**RFI**

**RFI #: 110**  
**Date:** 4/16/2012  
**Job:** EB-02 Keller Springs Lofts  
**Phone:** 877-777-5115

**Subject:** Ramp and Gradebeam at NW Corner of Garage

6 SECTION  
SCALE: 1/2"=1'-0"

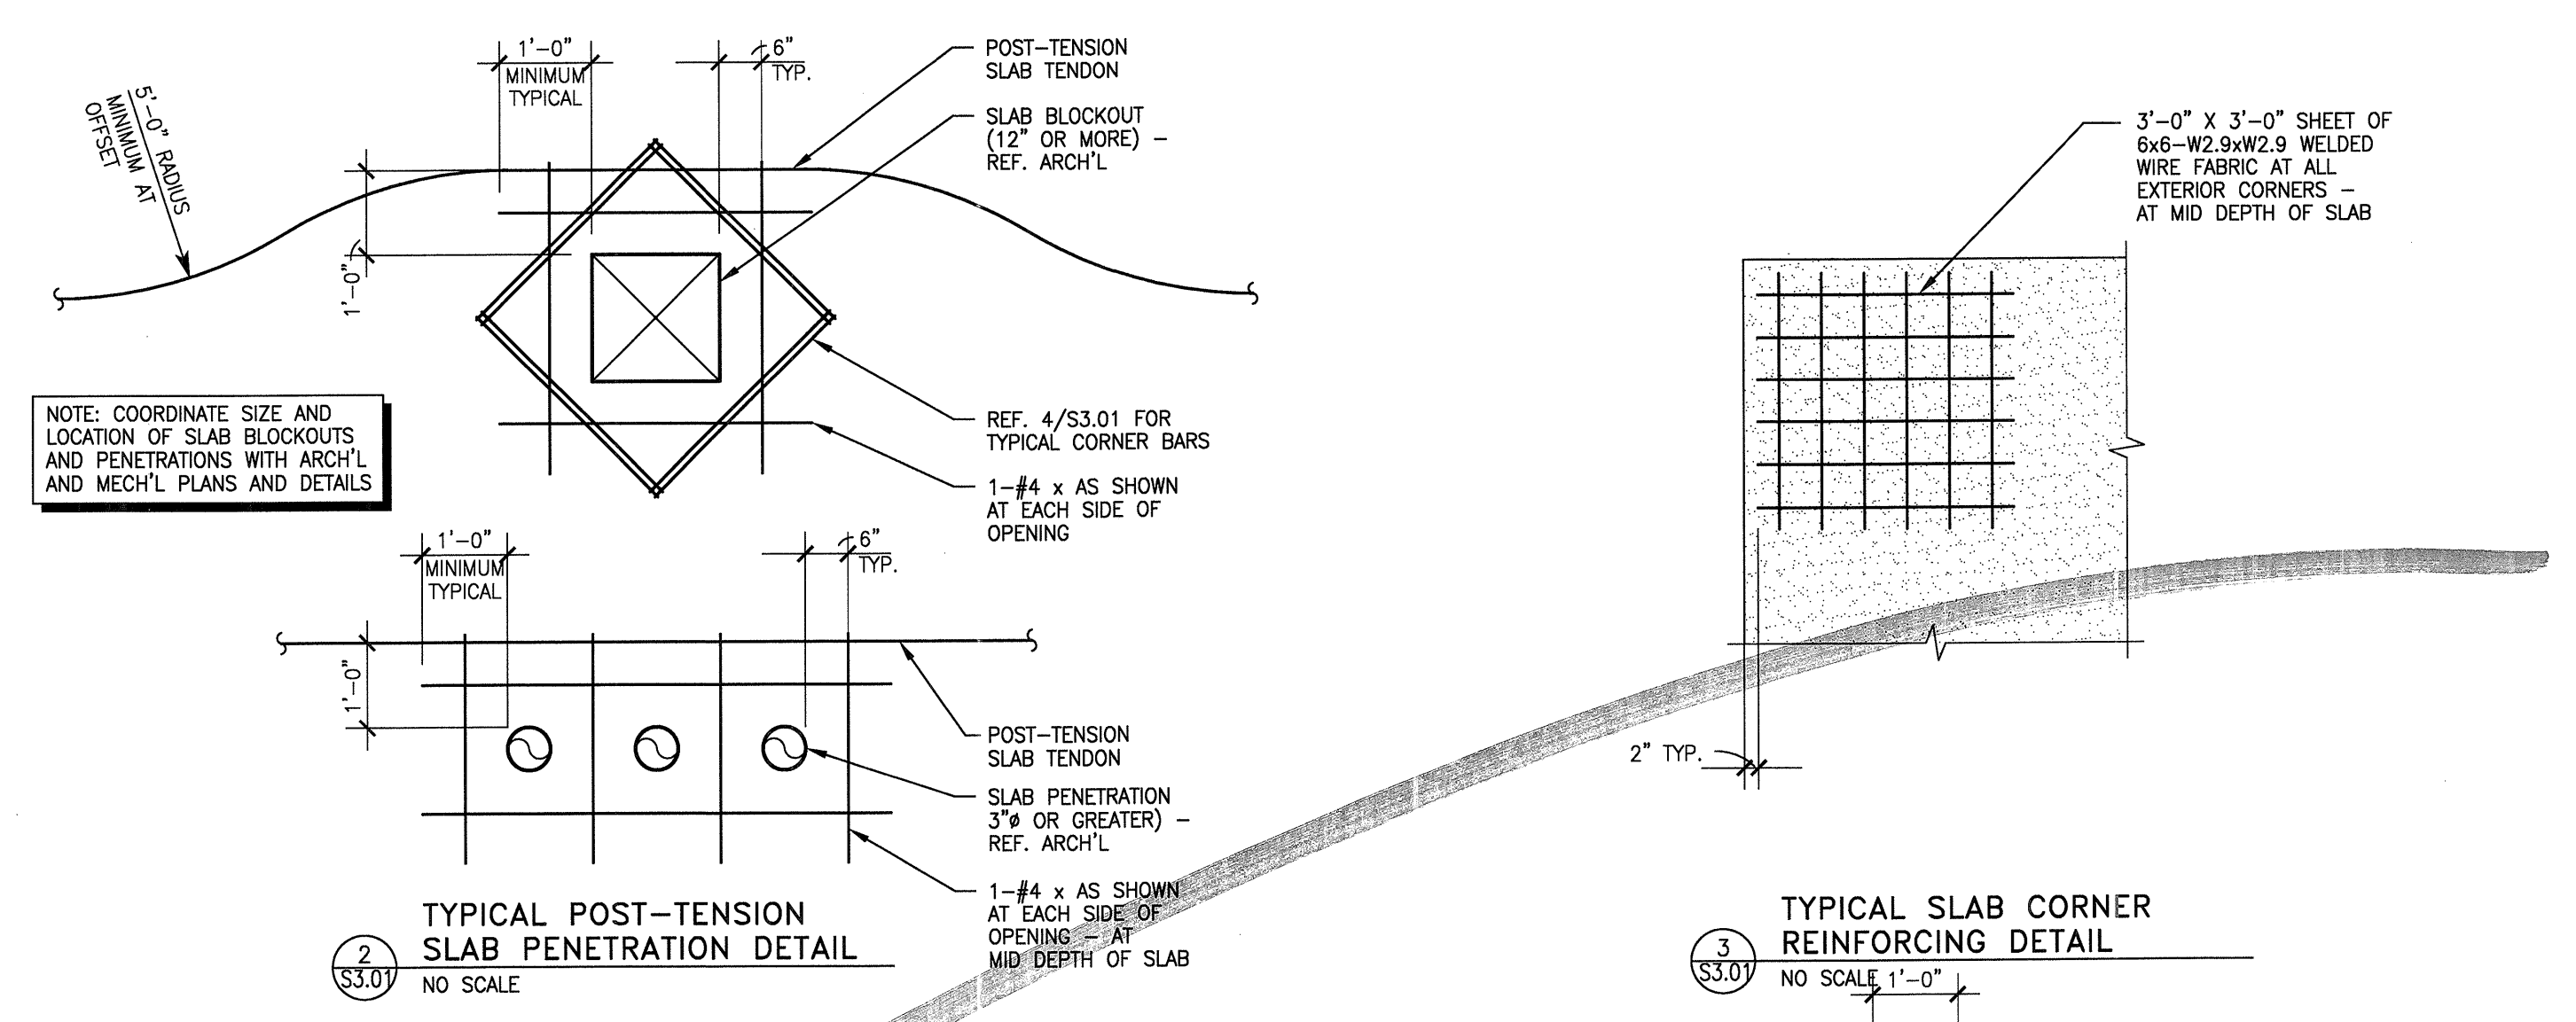
**Request:** The P5 top of pier elevation at the SW corner of Pour 5 will not allow enough room for the ramp. FF should be at 640.1, which would mean we would have a shorter gradebeam than the typical 2'-0". Please confirm if we are to have an 18" gradebeam there and also confirm where the stepdown is from the P9 pier to the P5 pier. Also provide a detail or cut through that area.

**Response:**  
Step top of grade beam down 6" at ramp only. Grade beam depth to remain 24" at all other areas.  
See 6/S3.01 for additional information.

**Request:** Structural plans call for these posts to be 6" wood. Architectural calls for these to be 8". With the height of these columns (11 - 13 plus feet), should they be steel? Also, how do the structural beams attach to the columns, whether wood or steel?

**Response:**  
Per BGO, use 8x8 posts.  
Fasten beams with Simpson CQ Post Cap and to foundation with Simpson ABU Post Base.  
R. Trent Perkins, P.E.  
Parkin-Perkins-Olsen Consulting Engineering, Inc.
